National Highways Planning Response (NHPR 22-12) Formal Recommendation to an Application for Planning Permission

Council's Reference: 2022/91477

Location: Land off Lindley Moor Road, Lindley, Huddersfield

National Highways Ref: 95504

REV	DATE	DESCRIPTION
PROJECT		
LINDLEY MOOR ROAD, LINDLEY MOOR		
TITLE		
DEVELOPMENT TRAFFIC (FIRST PRINCIPLES)		
SCALE		
NTS @ A3		
DRAWING		
2061 - 108		
DATE		
05.01.2023

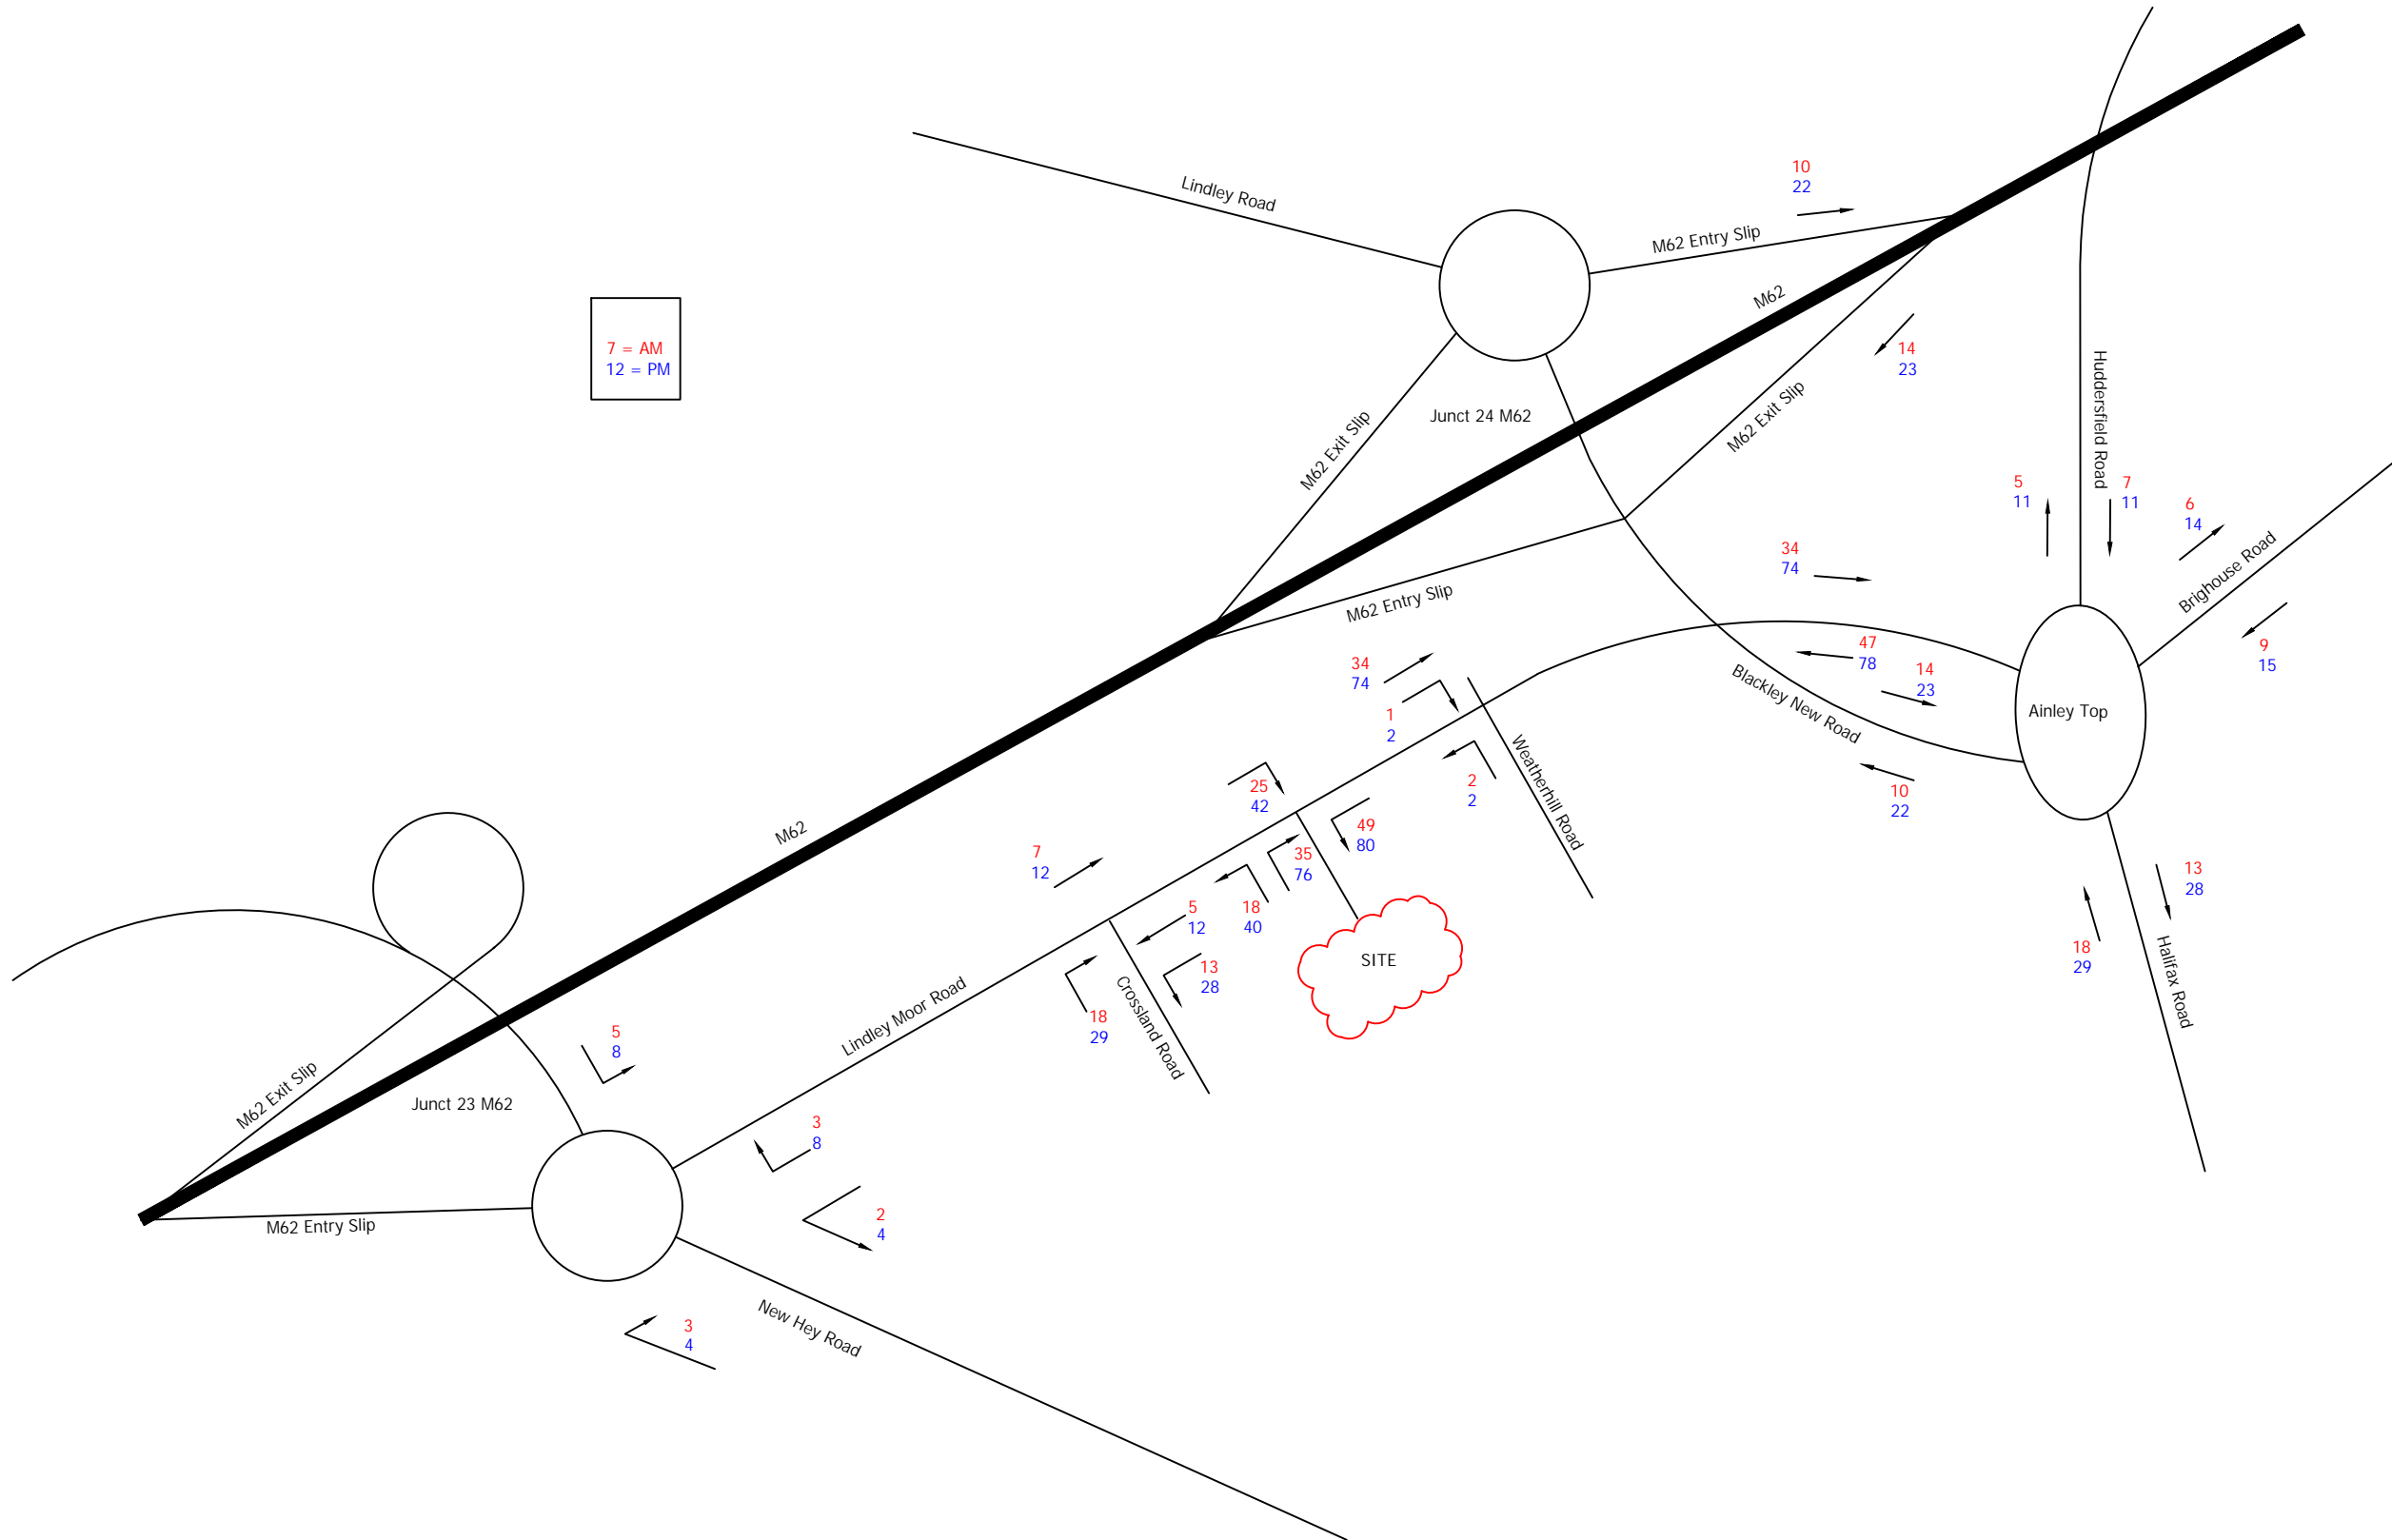
JSJV Comment – A traffic flow diagram has been produced by Paragon to demonstrate the flows generated by Unit P through the study area. This is welcomed by JSJV, as it shows the number of trips accessing the SRN – M62 Junction 24 – in the morning and evening peaks; namely 24 two-way trips in the morning peak and 45 two-way trips in the evening peak. Furthermore, there are 61 two-way trips in the morning peak and 101 two-way trips in the evening peak passing through the Ainley Top roundabout, as discussed above.

As such, JSJV do not agree with the conclusion reached by Paragon that the increase in flows is not significant, given the two-way flows stated alongside the JSJV consideration that a key issue in the operation of M62 Junction 24 relate to the operation of the local road network roundabout, causing queuing on Blackley New Road.
